16 April 2019

**Springvale Water Treatment Project (SSD 7592) MOD3**

I refer to your e-mail dated 14 March 2019 inviting WaterNSW's to provide advice on the Modification Report for the above modification application. WaterNSW appreciates the opportunity to provide comments on the report.

Figure 5-3 Approved condition vs proposed condition electrical conductivity on Coxs River at the confluence with Pipers Flat Creek

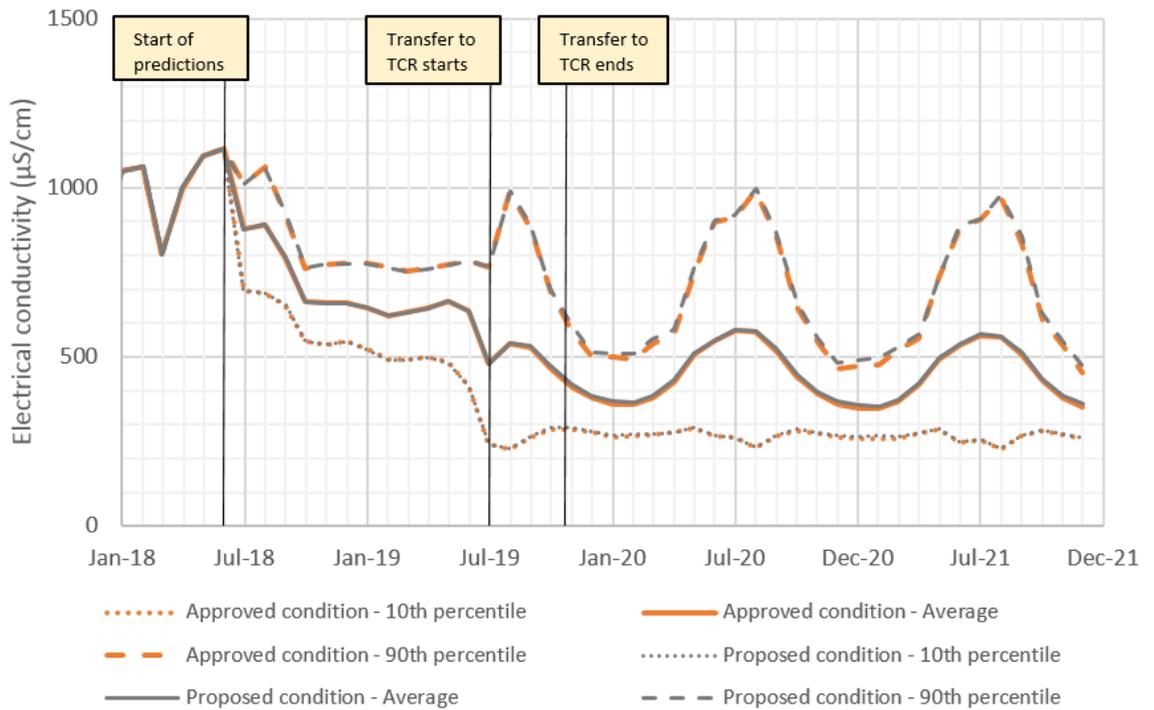
WaterNSW does not object to this modification, considering overall improvements in the water quality of the Coxs River catchment due to the cessation of high salinity mine water discharges from LDP009. WaterNSW considers that a temporary increase of salinity (10 µS/cm) in the Coxs River (at the confluence with Pipers Flat Creek) is only negligible and notes that it will decrease through the progressive commissioning of reverse osmosis modules.
